1 Coolnahinch,
Dundrum Road,
Dublin 14

Re: Planning Appeal – 1 Coolnahinch, Dundrum Road, Dublin 14 (D26A/0556/WEB)

TITLE
PROPOSED FLOOR PLANS

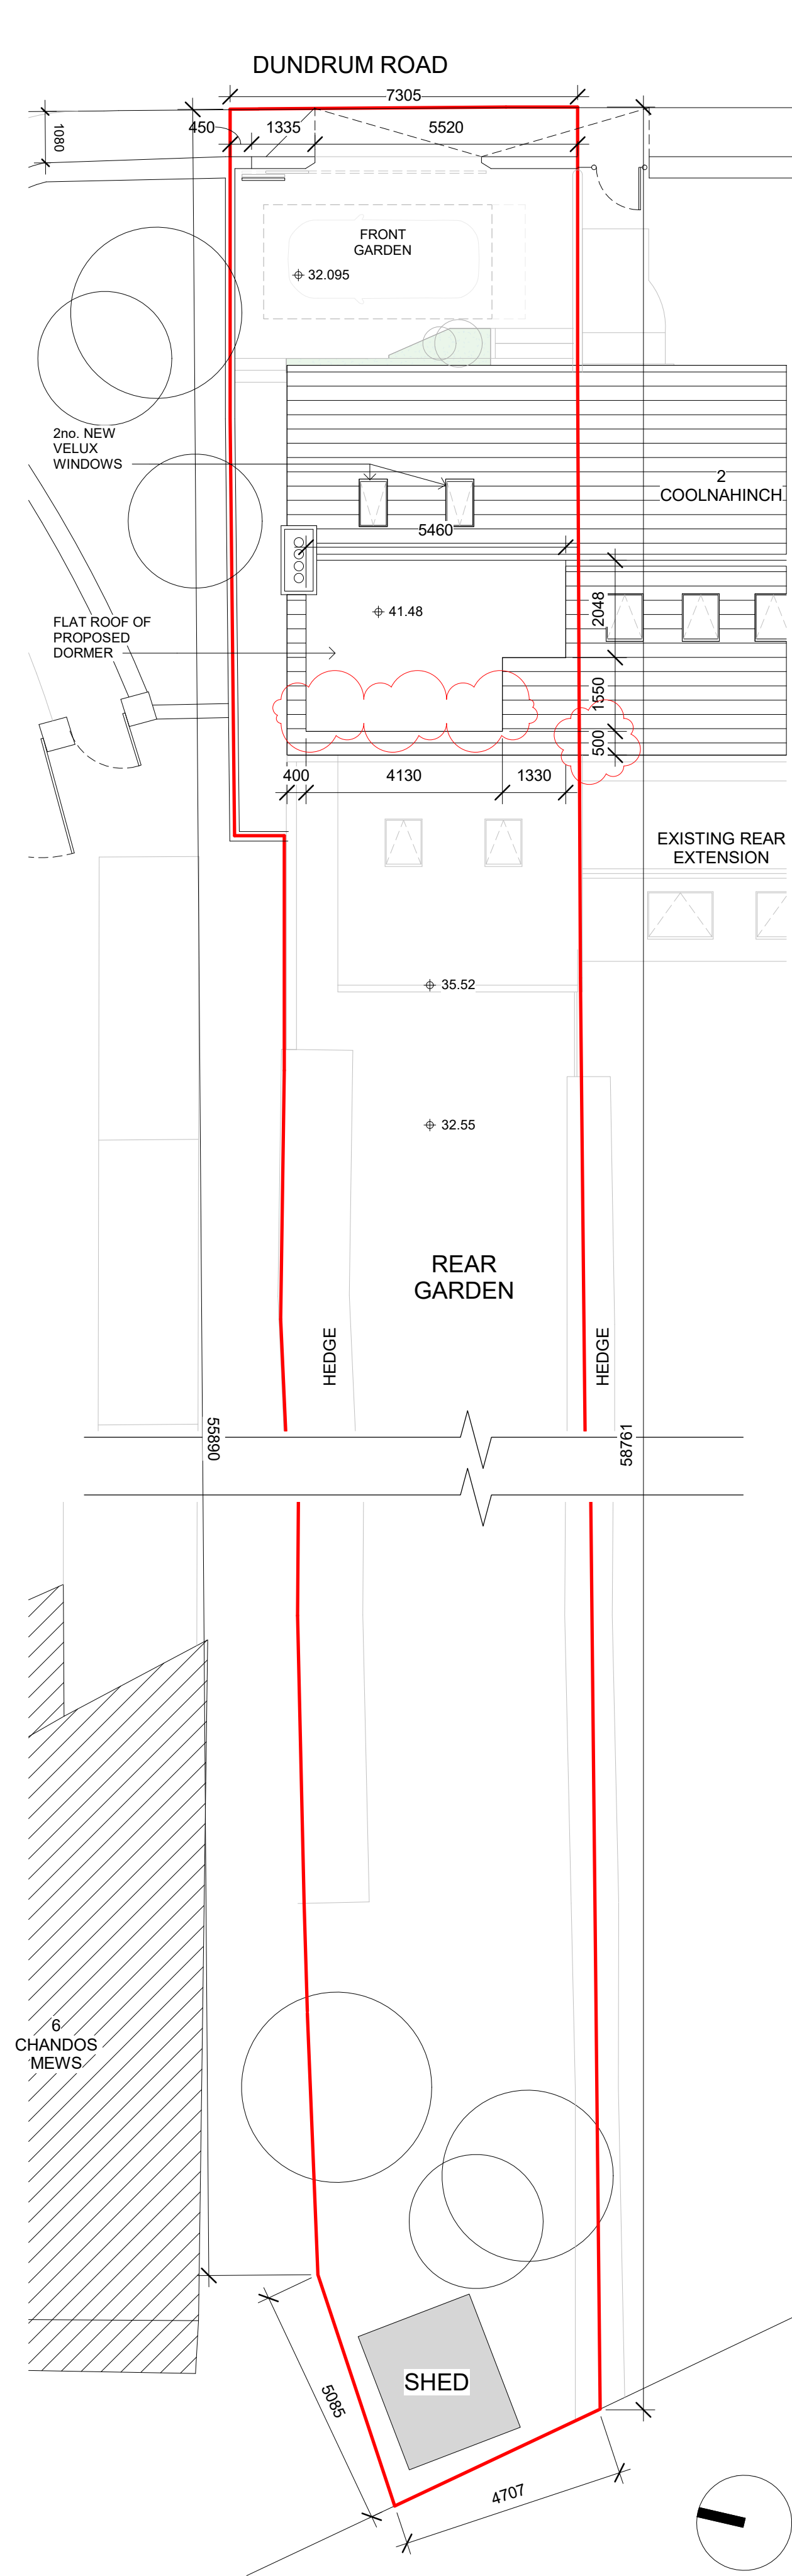
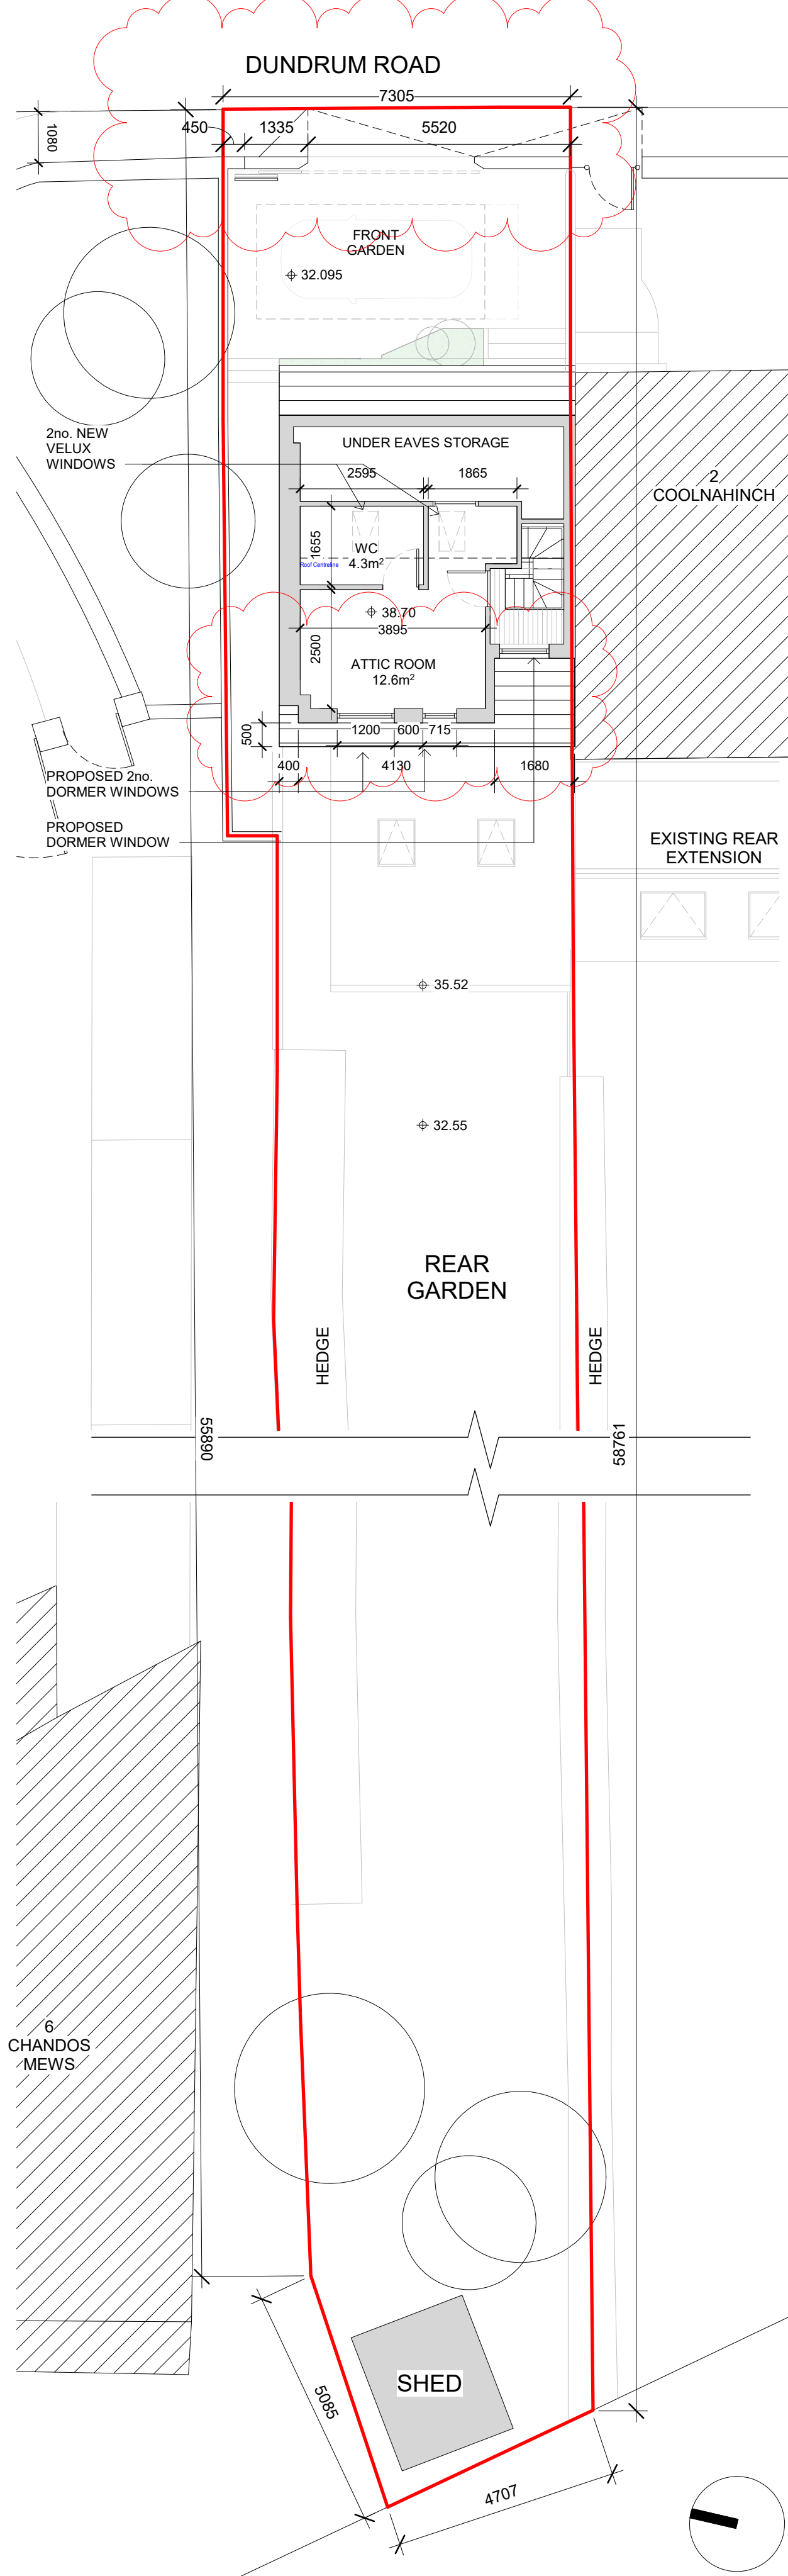
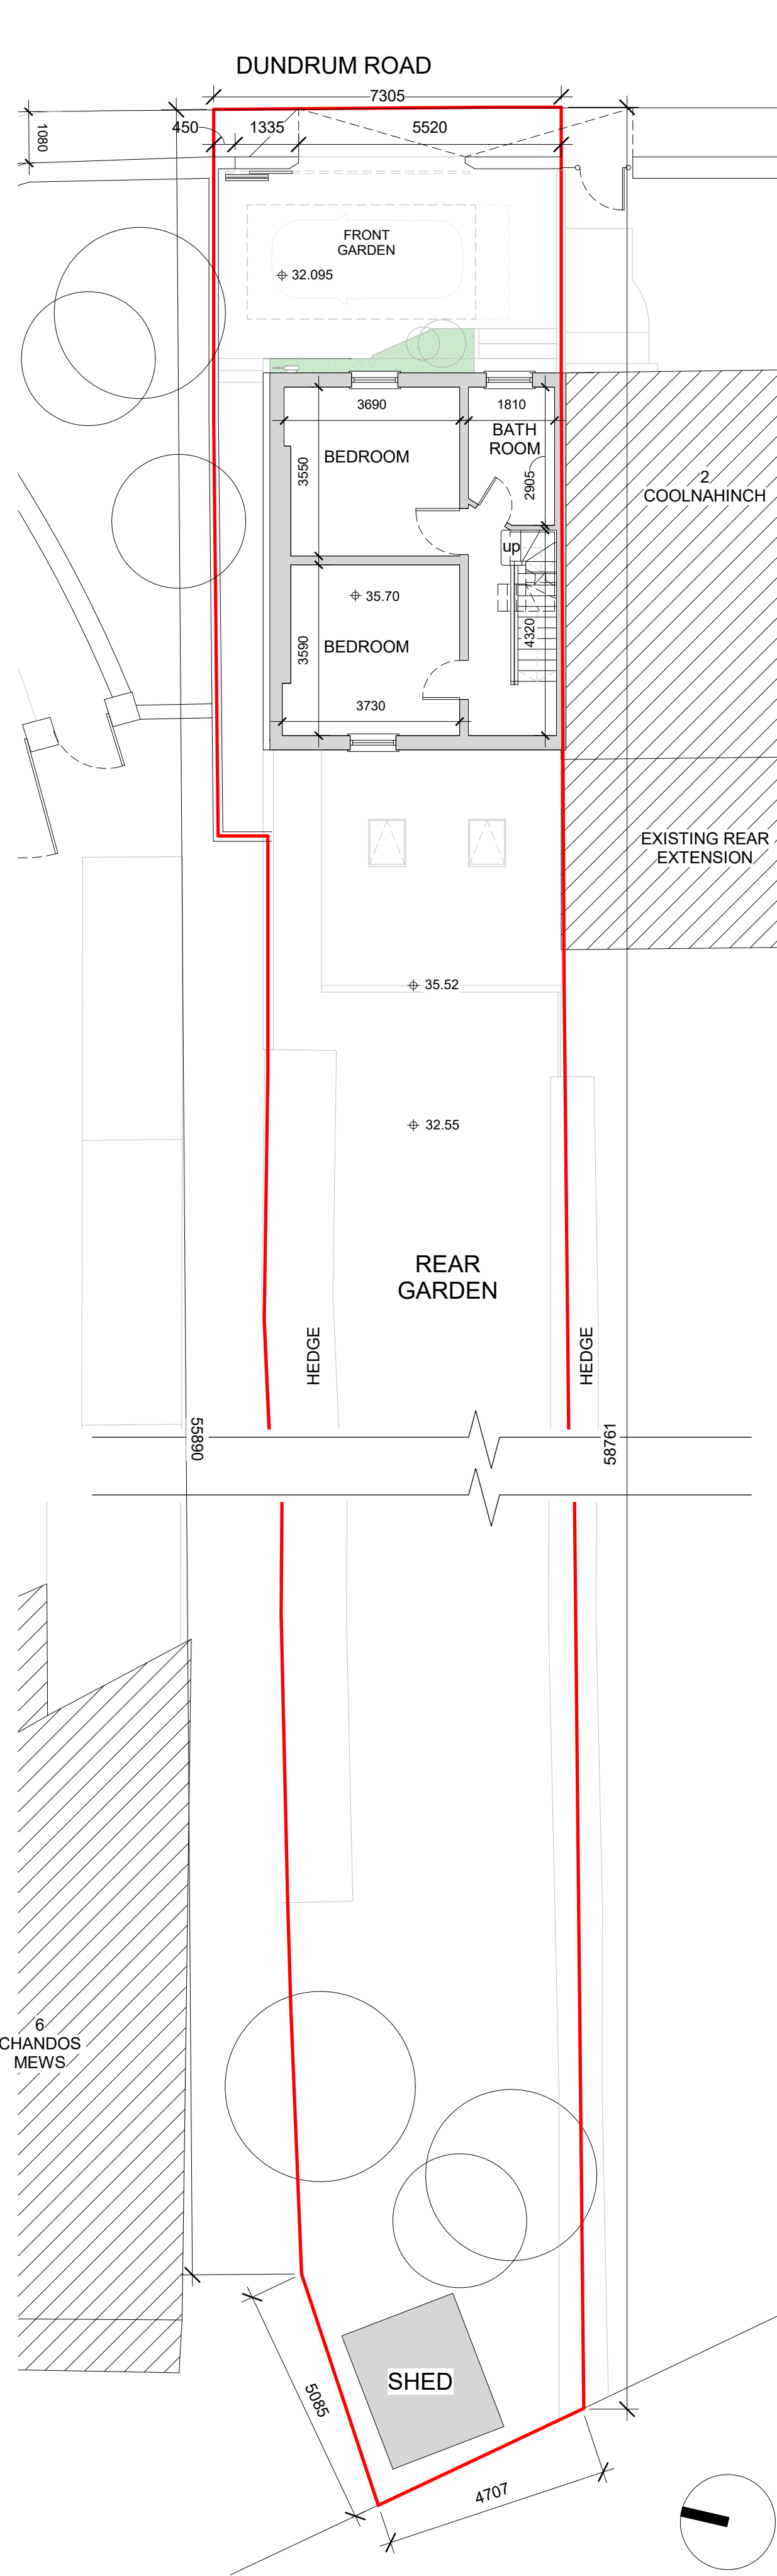
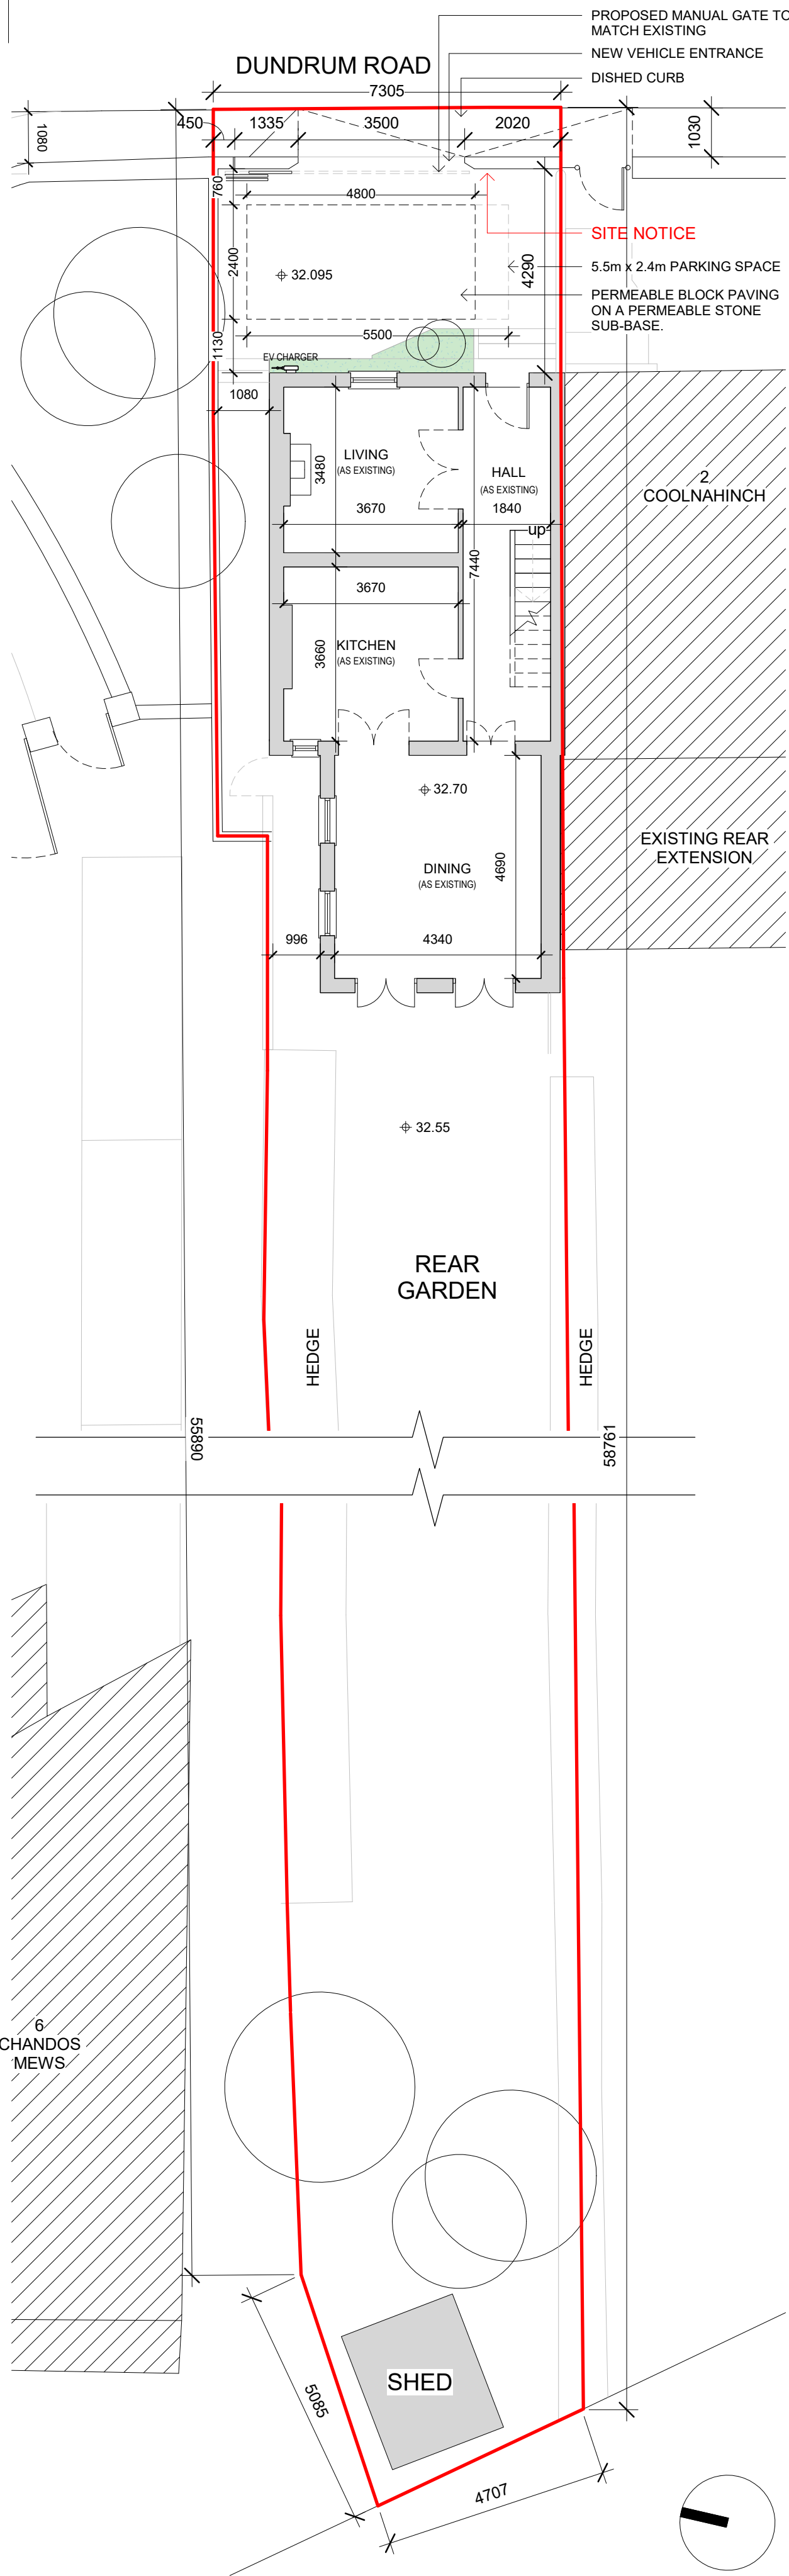
2. Having regard to the restricted dimensions of the front curtilage and the inability of vehicles to enter and exit the proposed parking space in a safe manner, it is considered that the proposed vehicular entrance and associated off street parking arrangement would result in unsafe vehicular manoeuvring and would adversely impact upon road and pedestrian safety. The proposal would therefore be contrary to Sections 12.4.8 and 12.4.8.2 of the Dún Laoghaire Rathdown County Development Plan 2022 to 2028 and contrary to the proper planning and sustainable development of the area"

In consideration for this appeal, it is worth noting that the Planners Report noted that the *“Proposed Floor Plans (Drawing No. 005) demonstrated 1no. 4.4m x 2.4m parking space.”* This appears to be an error as the drawing shows a 5.5m x 2.4m parking space in line with the Development plan. The parking space can comfortably fit within the overall width of the curtilage, circa 7.3m. and at its deepest 3.9m.

The previously submitted scheme has been amended to improve vehicle manoeuvrability into and within the site. The revised layout provides a parking bay depth of circa 7.3 metres, and a revised centralised entrance, which allows sufficient space for a vehicle to either drive directly into the parking space or reverse into it, depending on the driver's preference and prevailing traffic conditions. This DIRO or RIDO approach is consistent with the permitted schemes noted above, and on this basis it would be considered that the amended design adequately accommodates the manoeuvring requirements of a private vehicle and facilitates safe access to and from the site.
